EC Road Safety

8th February 2017

Orchard Gardens, Woodgate, West Sussex - RSA

I note that following this Stage 1 road safety audit carried out in 2015 on the preliminary design, the scheme has progressed and as a result a number of amendments are now proposed. Thank you for sending me a copy of the revised plan 5919/100 revision C and I would offer the following comments regarding the proposed alterations to the original roads safety audit plan.

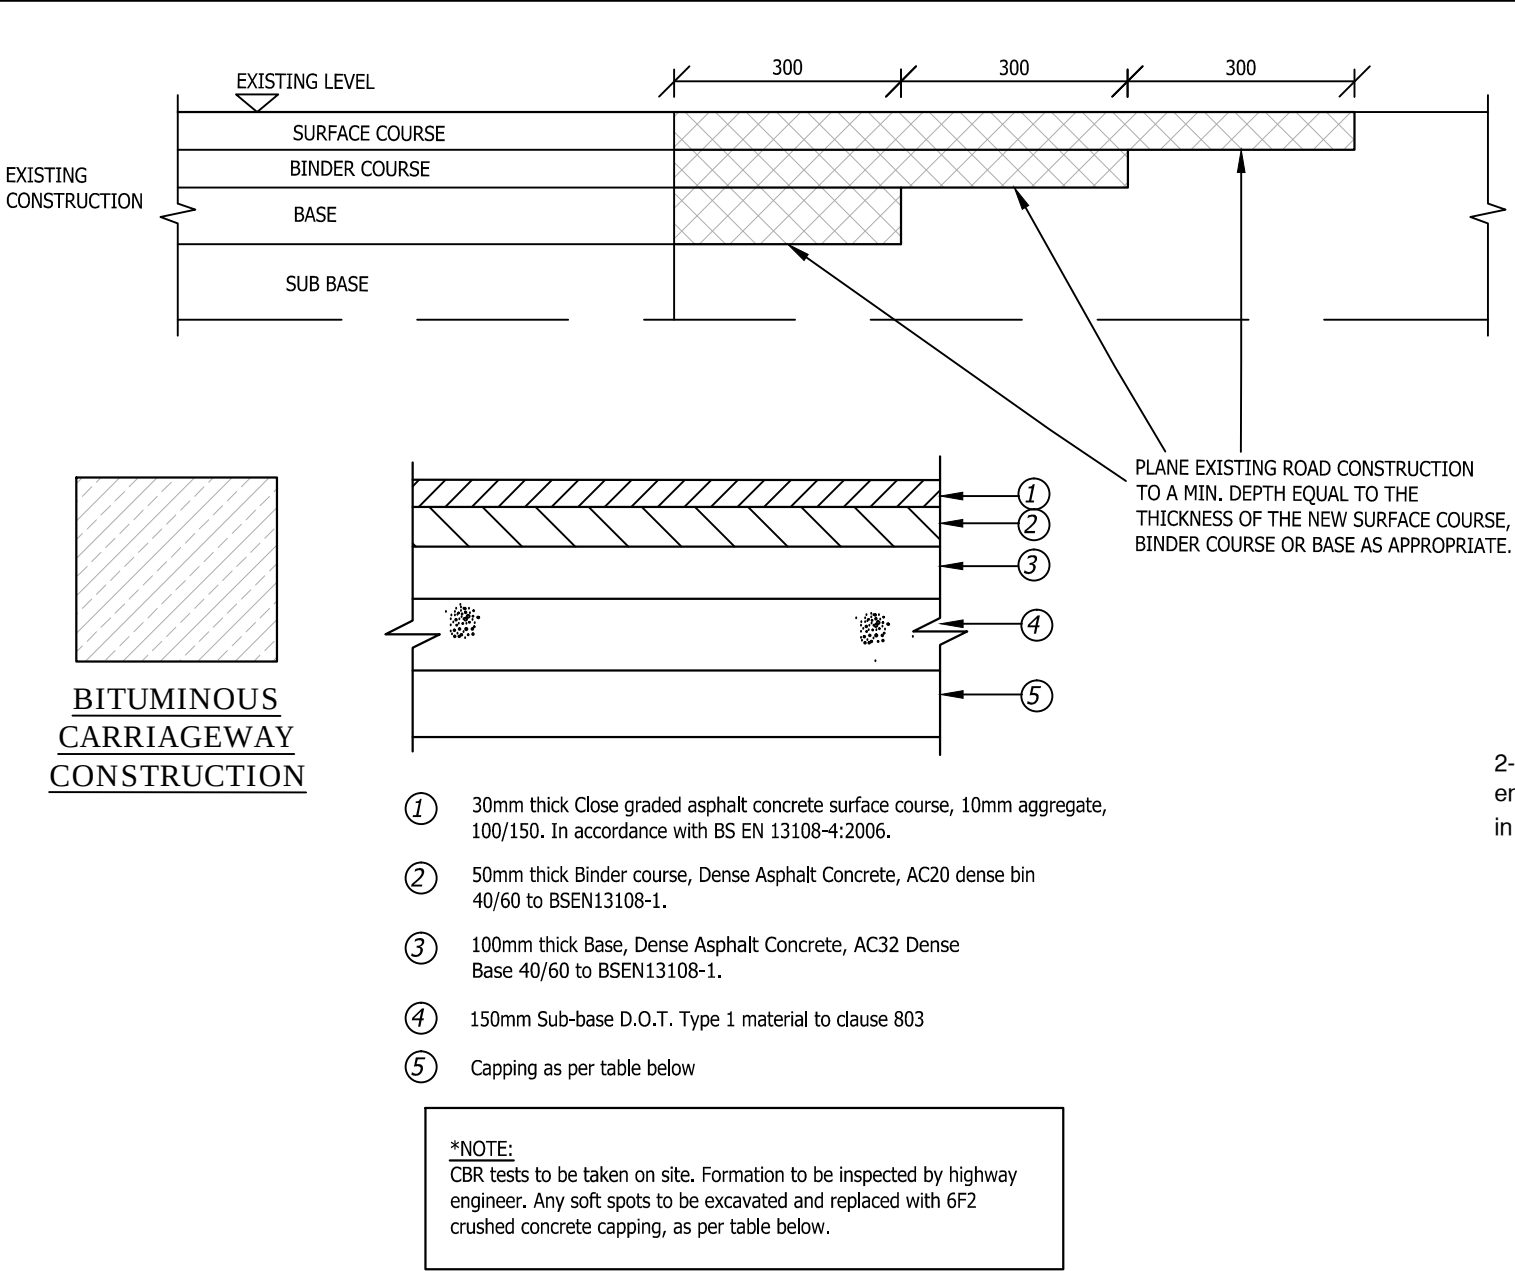
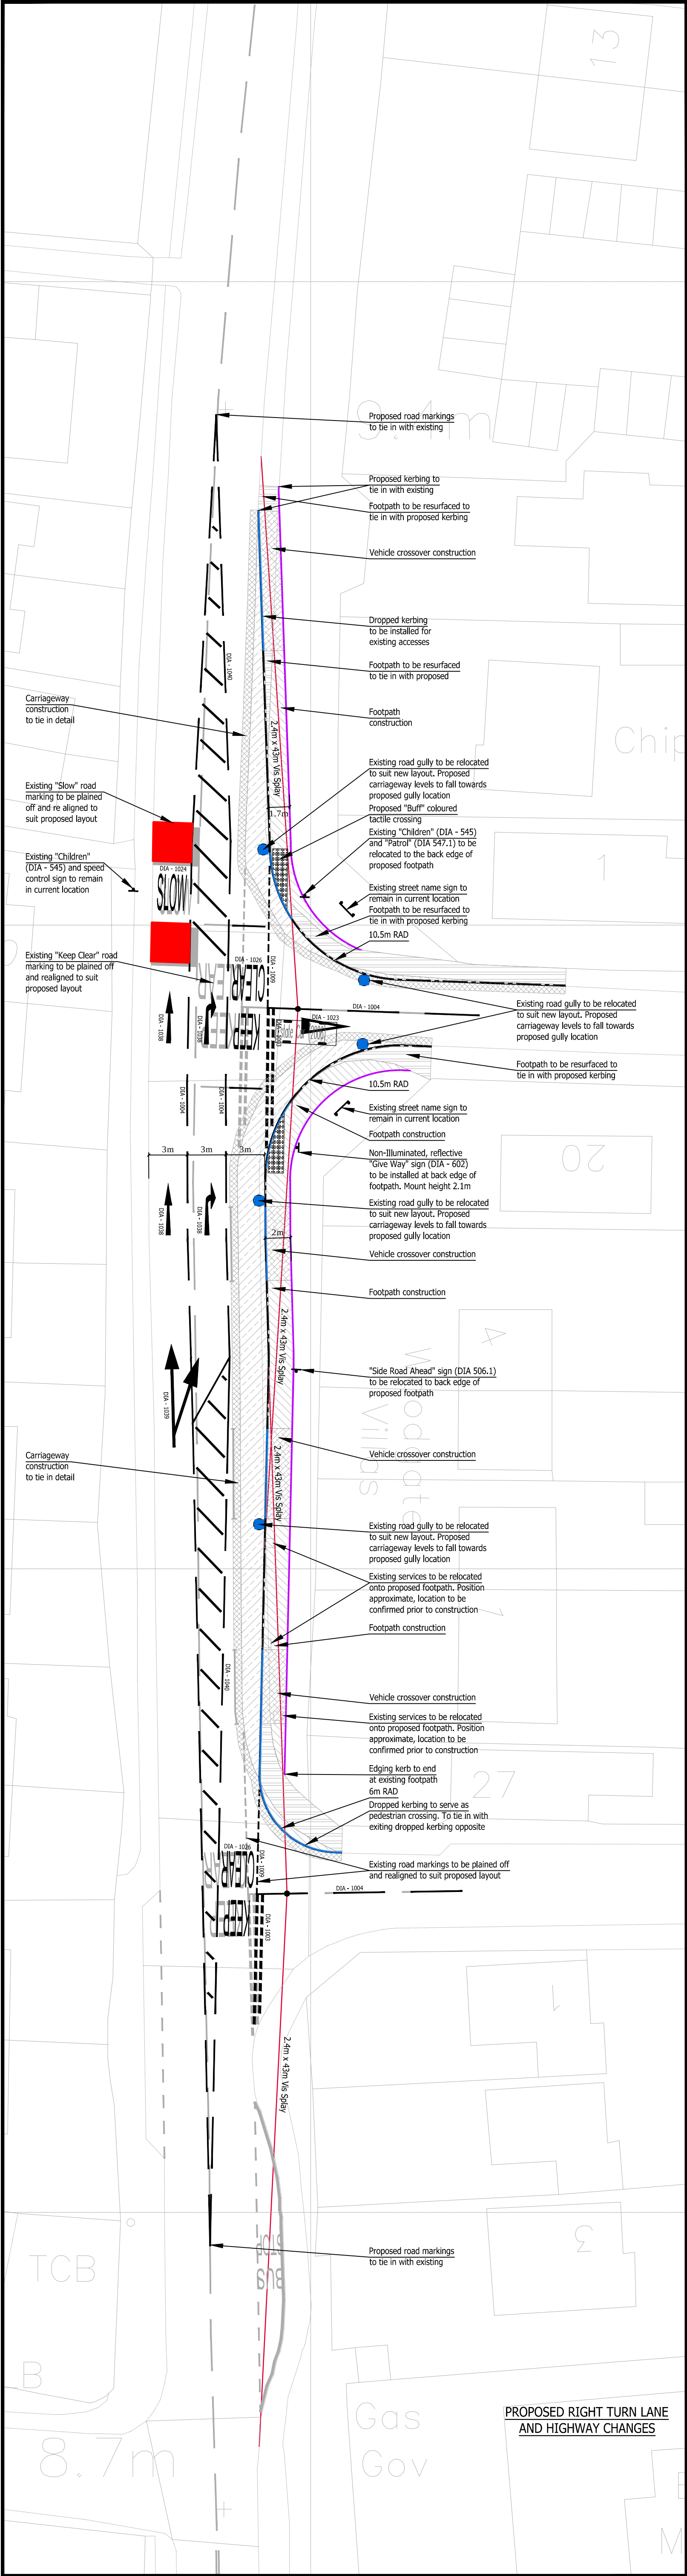
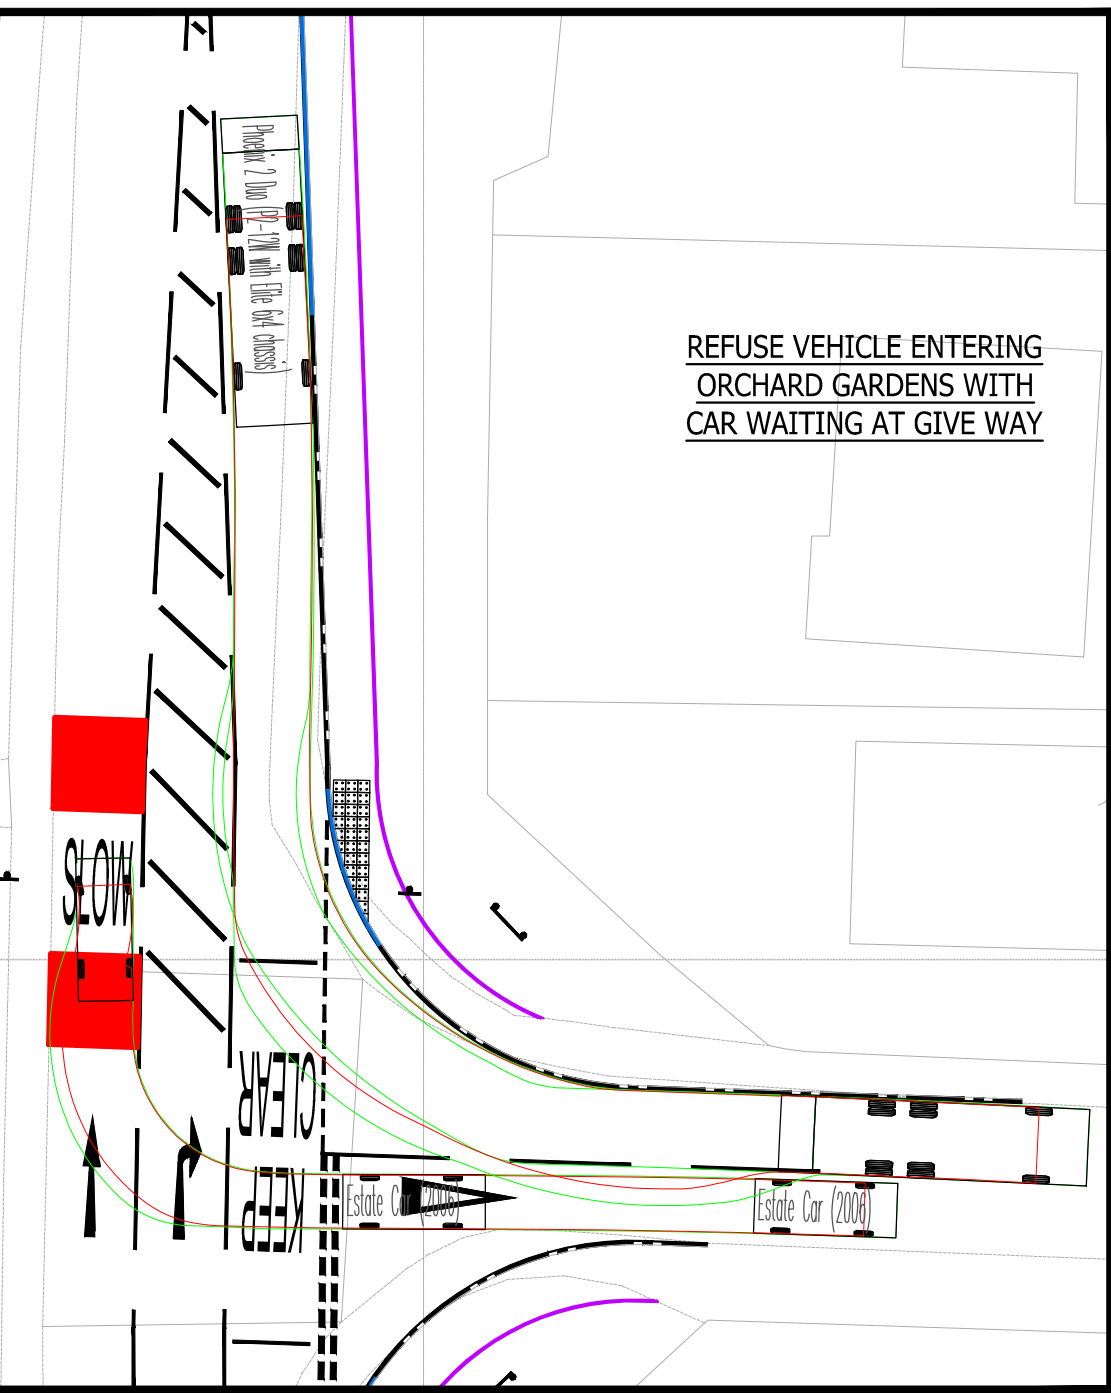
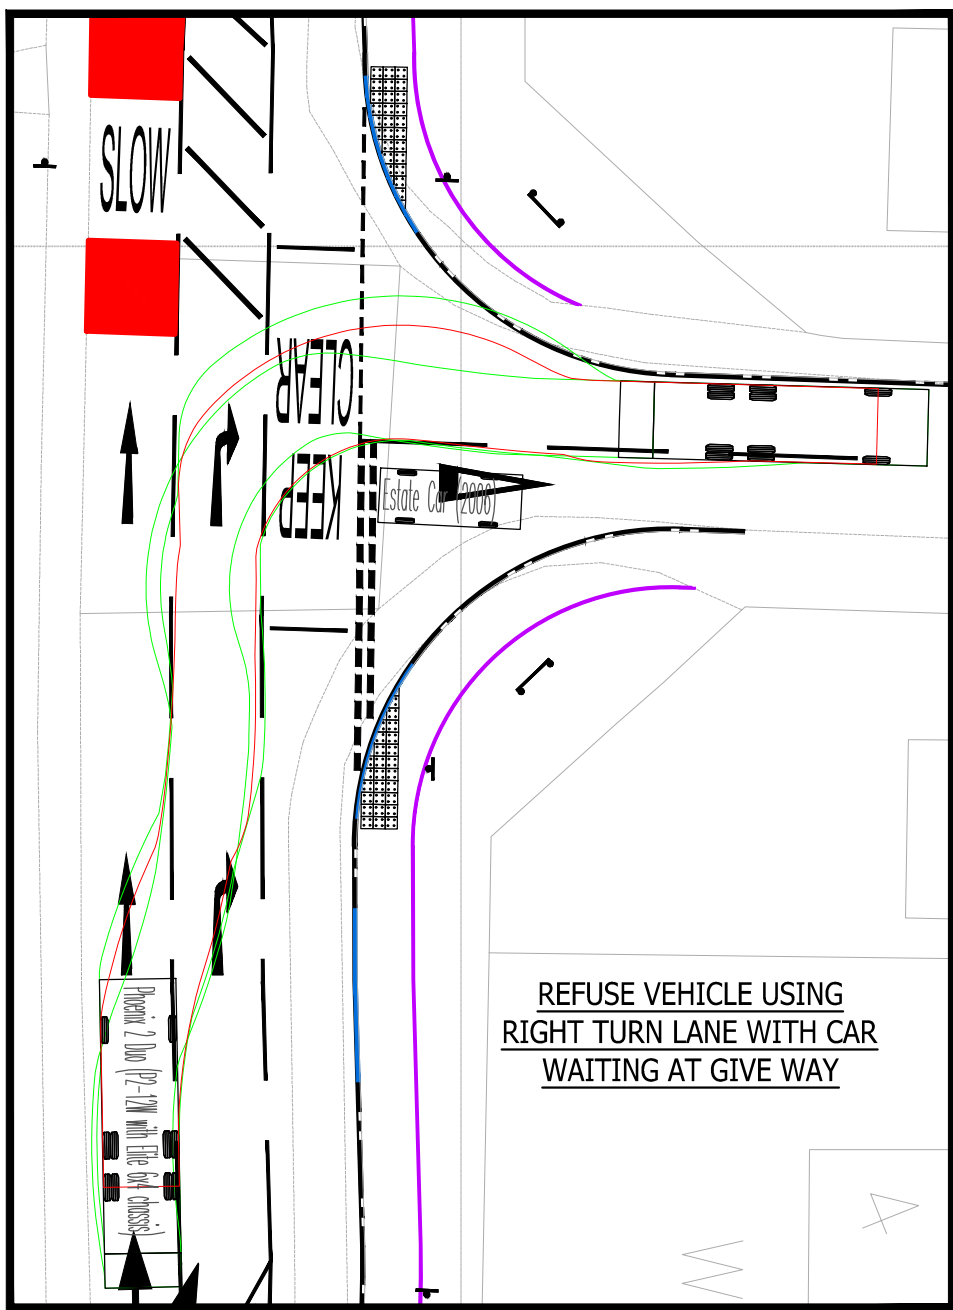
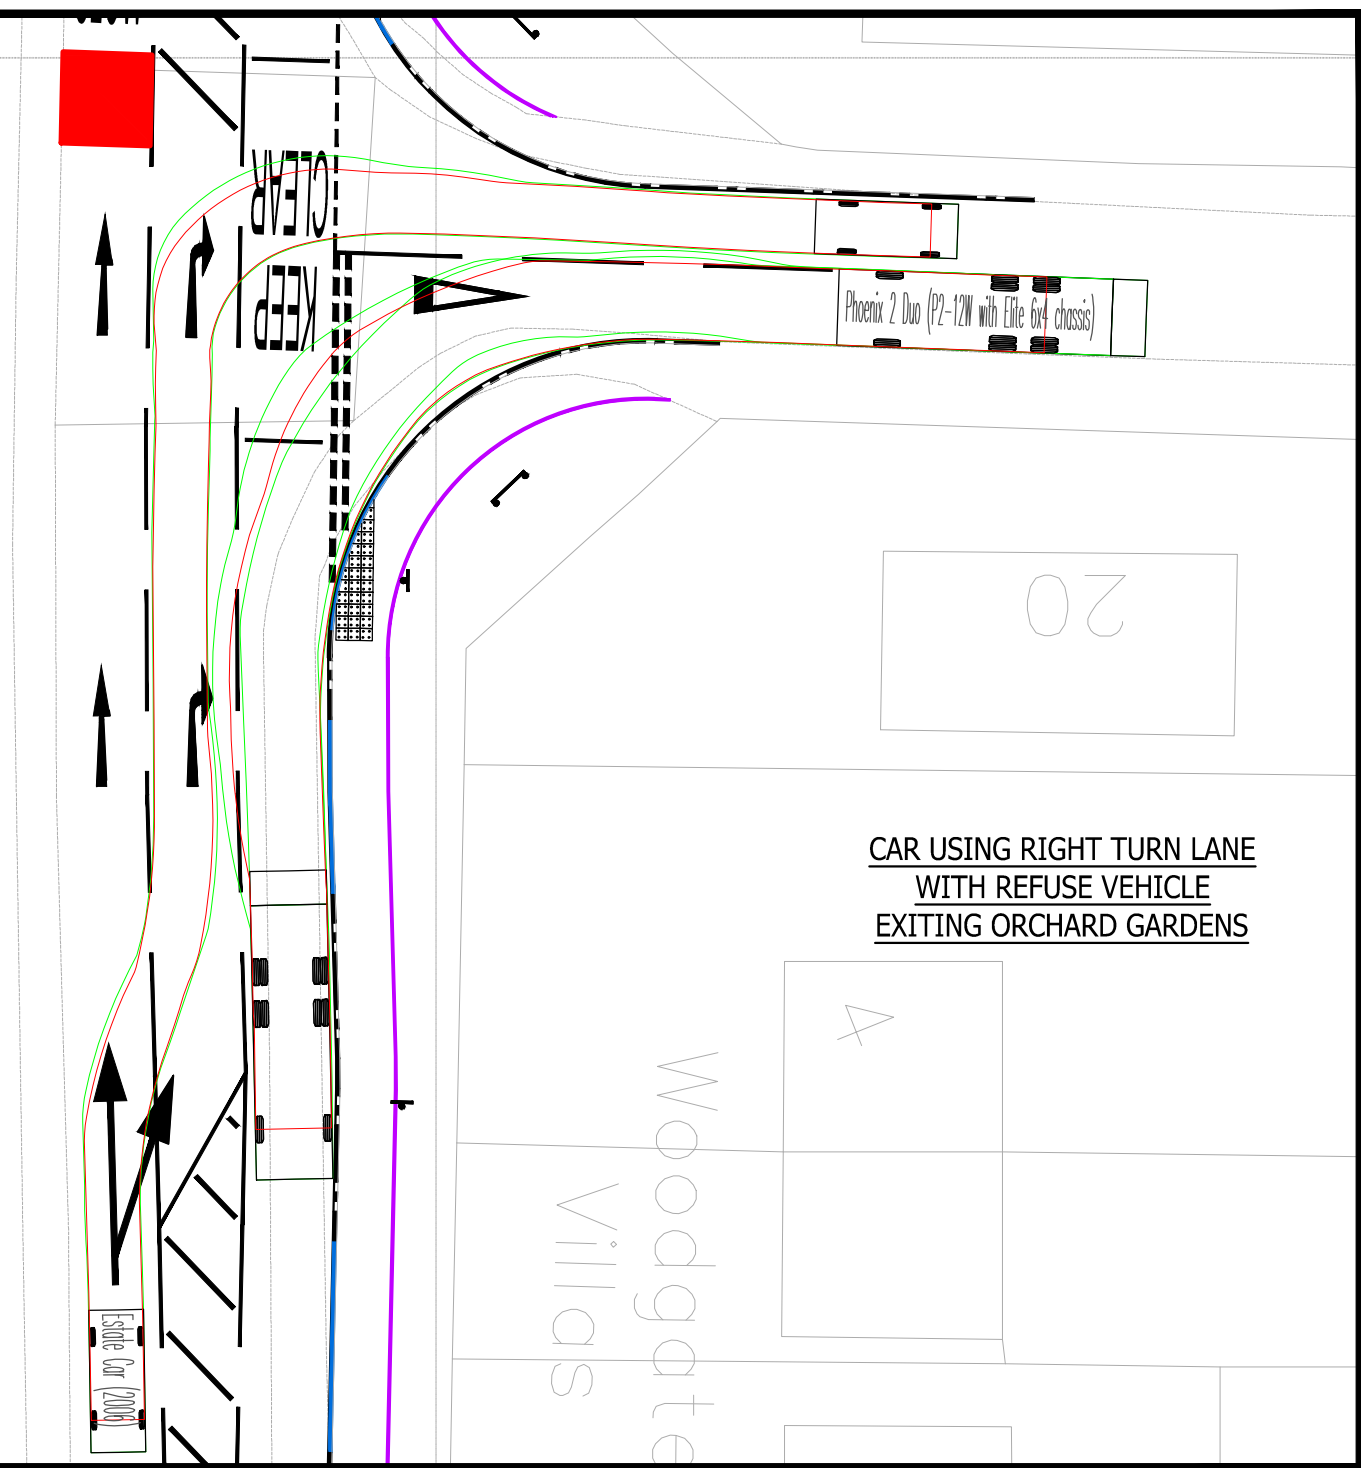
- The swept paths included on the revised plan indicate that larger vehicles can manoeuvre without overrunning the A29 and or adjacent footways. The original showed a slight over run, even if the turning manoeuvre was exaggerated by the auto track plots.

- The revised plan includes the relocation of the bus stop that would be closer to the Orchard Gardens junction. Whilst there would be no objections from a road safety view to the bus stop, the revised plan sent through indicates that sightlines would not be obstructed with the set back of 2.4m and 43m in either direction. I believe that the set back is to be amended to 3.0m and if so, it will need to be ensured that the proposed bus stop shelter does not interfere with the sightline. It appears that there is room within the land indicated, but no obstruction to the sightline should occur.

- The addition of a pedestrian refuge island has been added between Orchard gardens and Belle Meade Close and from a road safety audit point of view this would help to provide an informal crossing point and

also improve lane discipline and prevent drivers overrunning the hatch markings to gain entry to the right turn lane, if queues were present on the main road.
